Rezoning Transportation Analysis

Petition Number: Zoning Petition #2021-011

General Location Identifier: Tax ID 10304127

Date	Description
02-25-21	First Review (WB)

ENGINEER: GTW
DRAWN BY: GTW
CHECKED BY: JB
PROJECT #: 019-011
SHEET
RZ-1
SHEET 1 OF 2

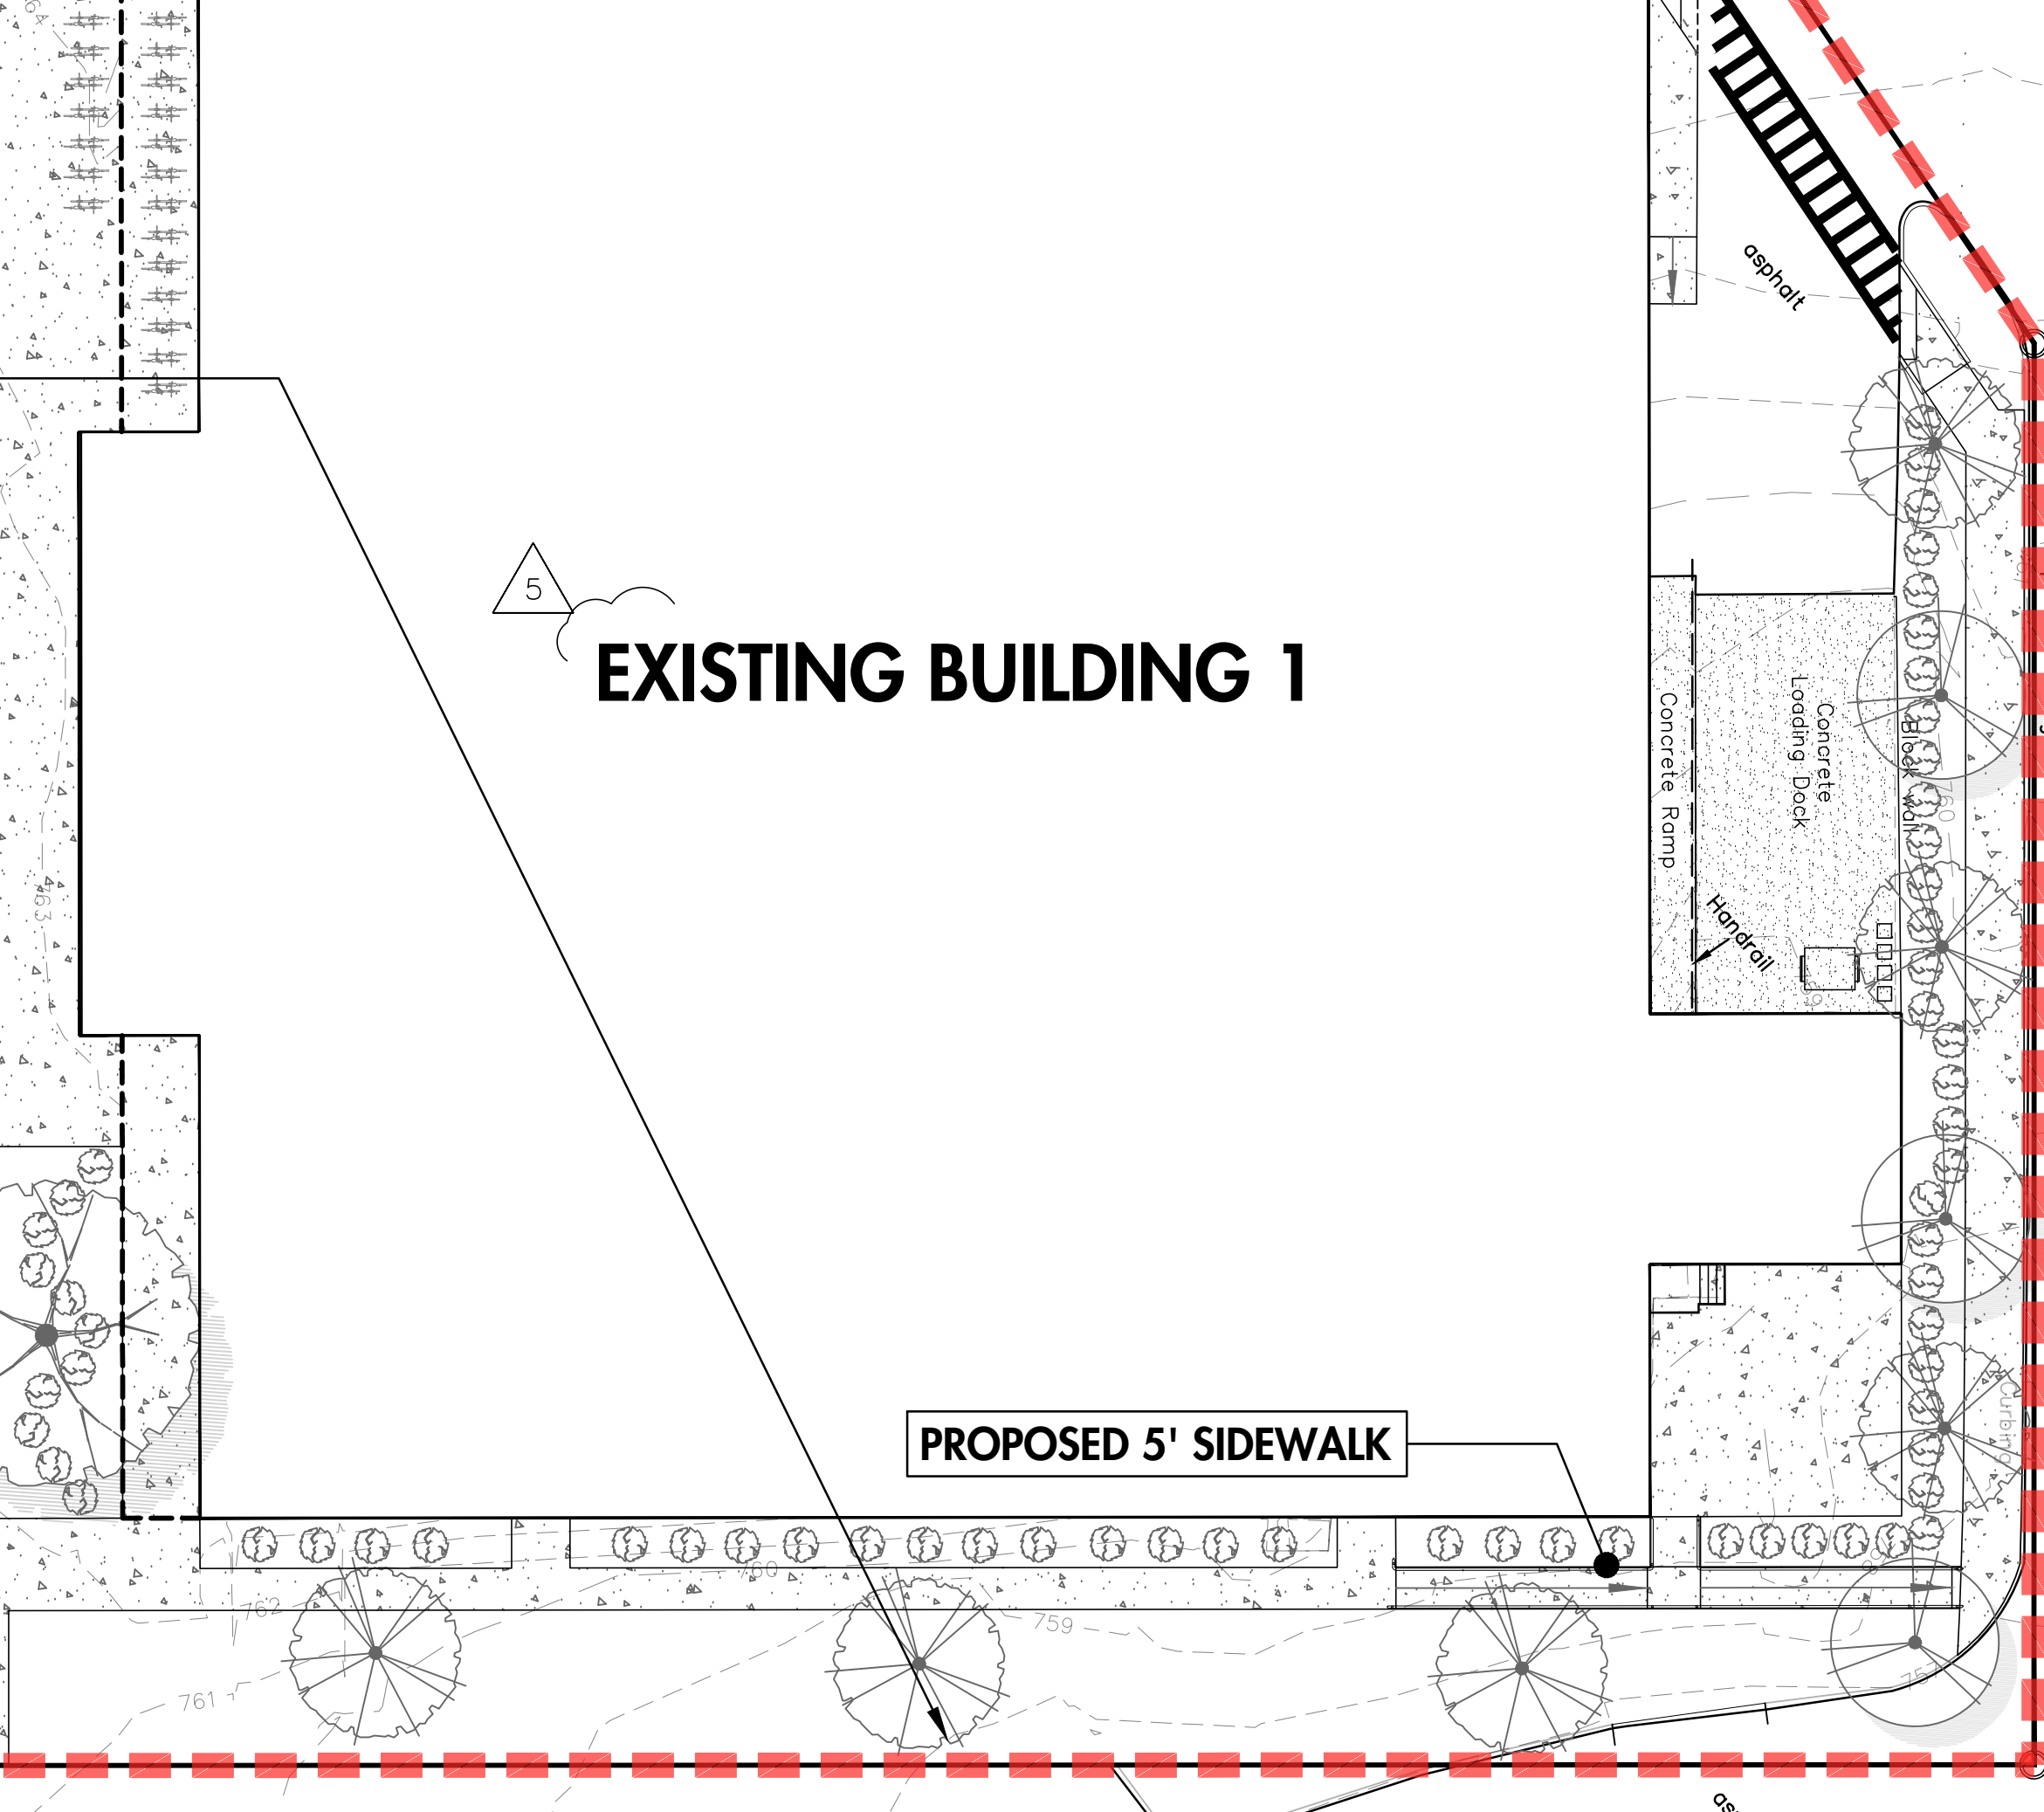
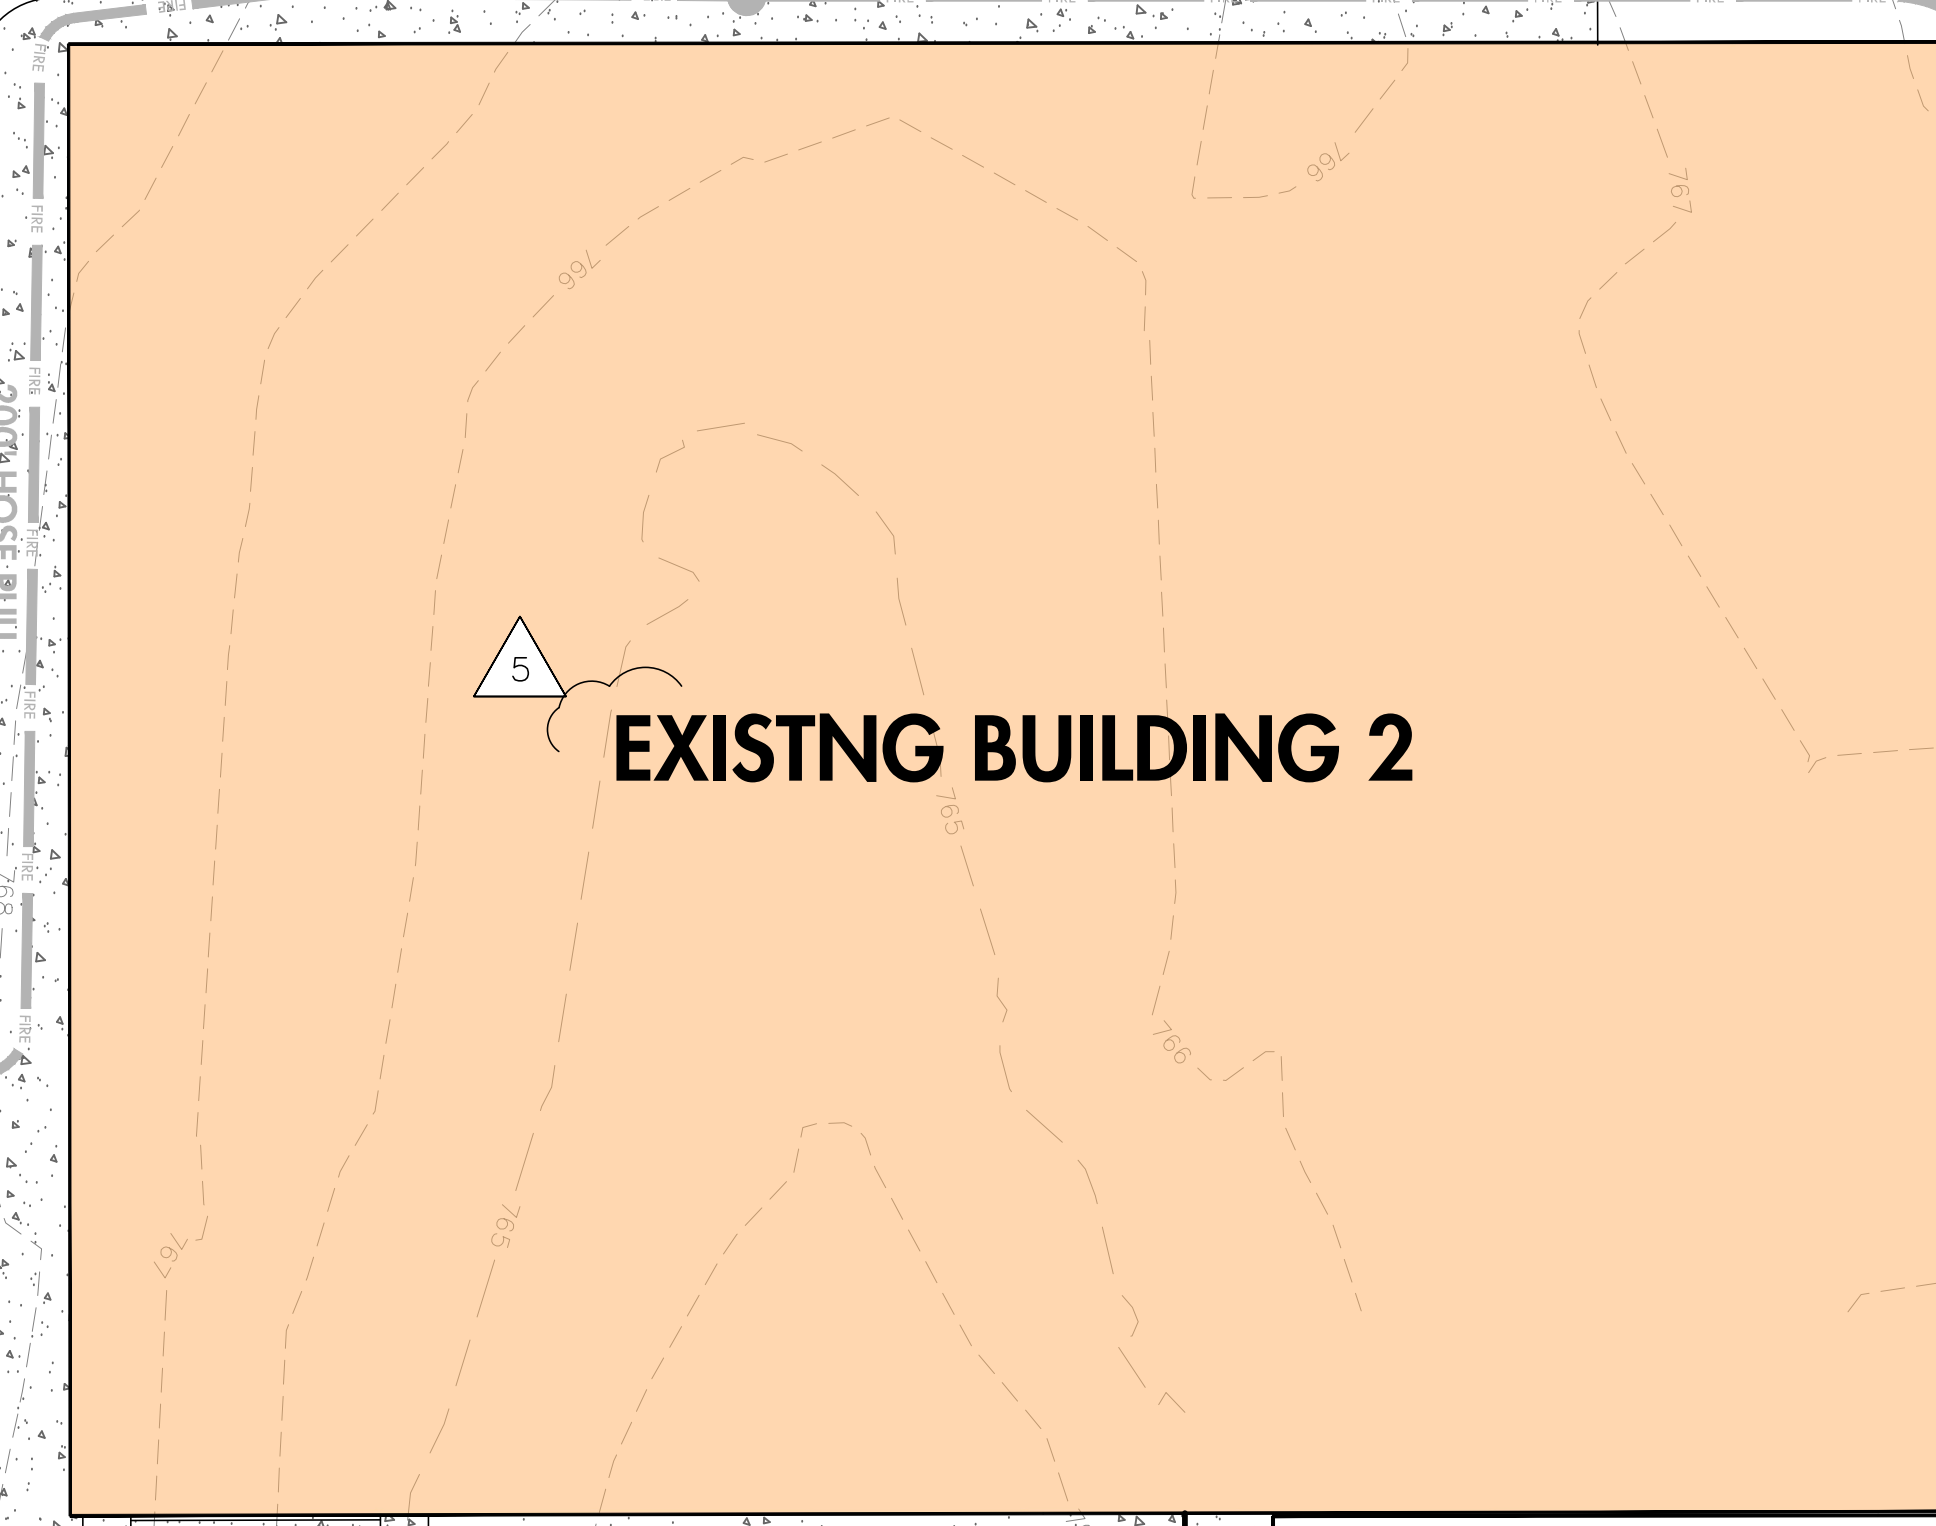
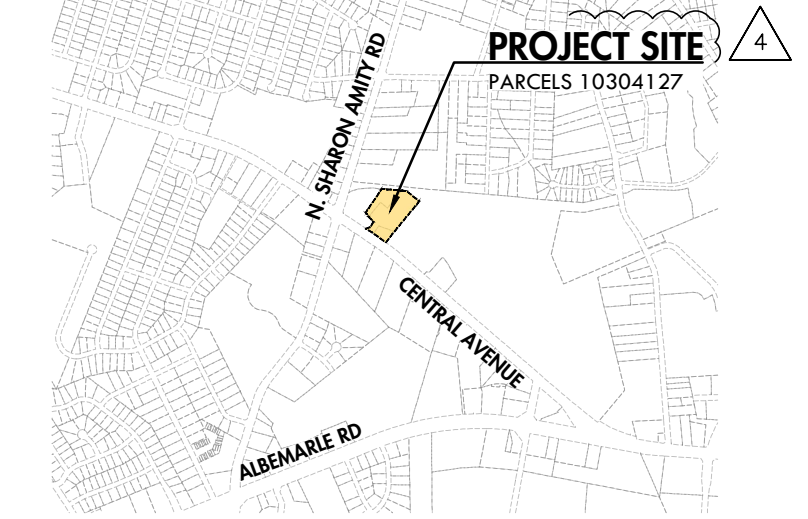
1. **Curblines:** The proposed zoning district has a setback measured from back of the existing or proposed future curblines.
 - a. **Central Avenue:** Location of curb and gutter needs to be at 38 feet from the centerline to allow for a 4+ Avenue with an 8-foot buffered bike lane.

Label and dimension the curb and gutter from the road centerline on the site plan.

3. Revise site plan and conditional note(s) to commit to construct an 8-foot planting strip, and 8-foot sidewalk on Central Avenue per Chapter 19. The wider sidewalk also meets the Charlotte WALKS Policy. The site plan shall label and dimension both items from the back of curb and gutter.

4. Site plan and conditional note(s) revisions are needed to commit to construct 8' buffered bicycle lanes by relocating the curb and gutter 38' from the center line to meet the City Charlotte BIKE Policy.
5. Revise or Remove Conditional Note B.1, based on the results of the Traffic Impact Study, which may not allow vehicular circulation or maneuvering to occur in the setback area between Central Avenue and the buildings.

RZ-2
SHEET 2 OF 2

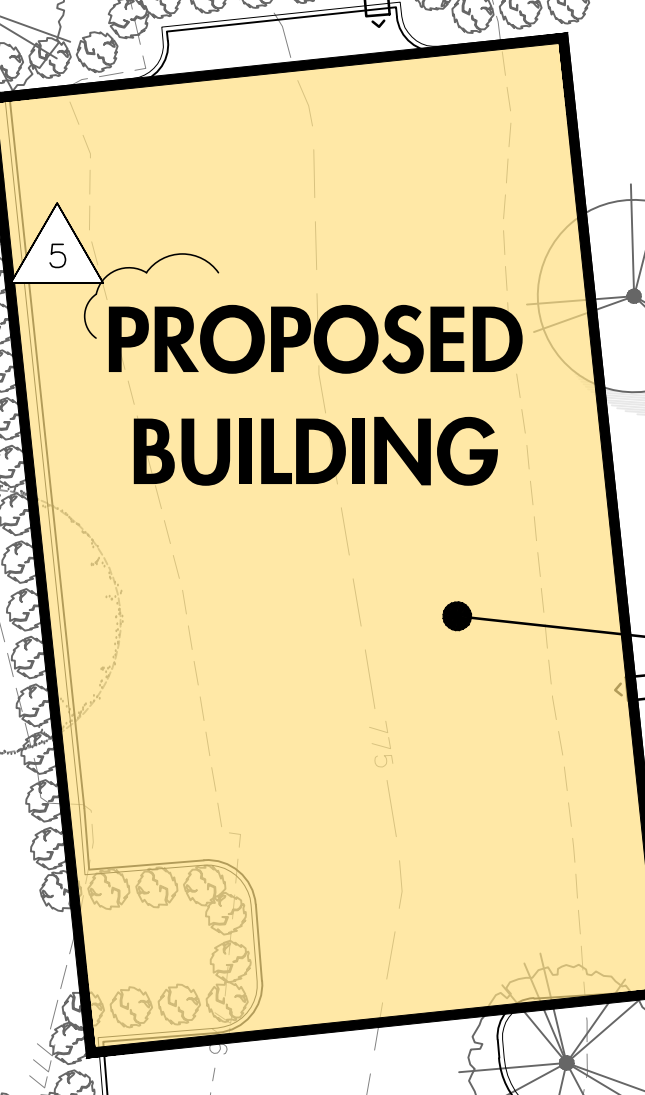
6. Remove Conditional Note D. 4. and replace it with "The Petitioner commits to constructing an 8-foot planting strip, and 8-foot sidewalk on Central Avenue per Chapter 19."
7. Add a site plan note specifying dedication and fee simple conveyance of all rights-of-way to the City before the site's first building certificate of occupancy is issued is needed. CDOT requests rights-of-way set at 2' behind back of sidewalk where feasible.
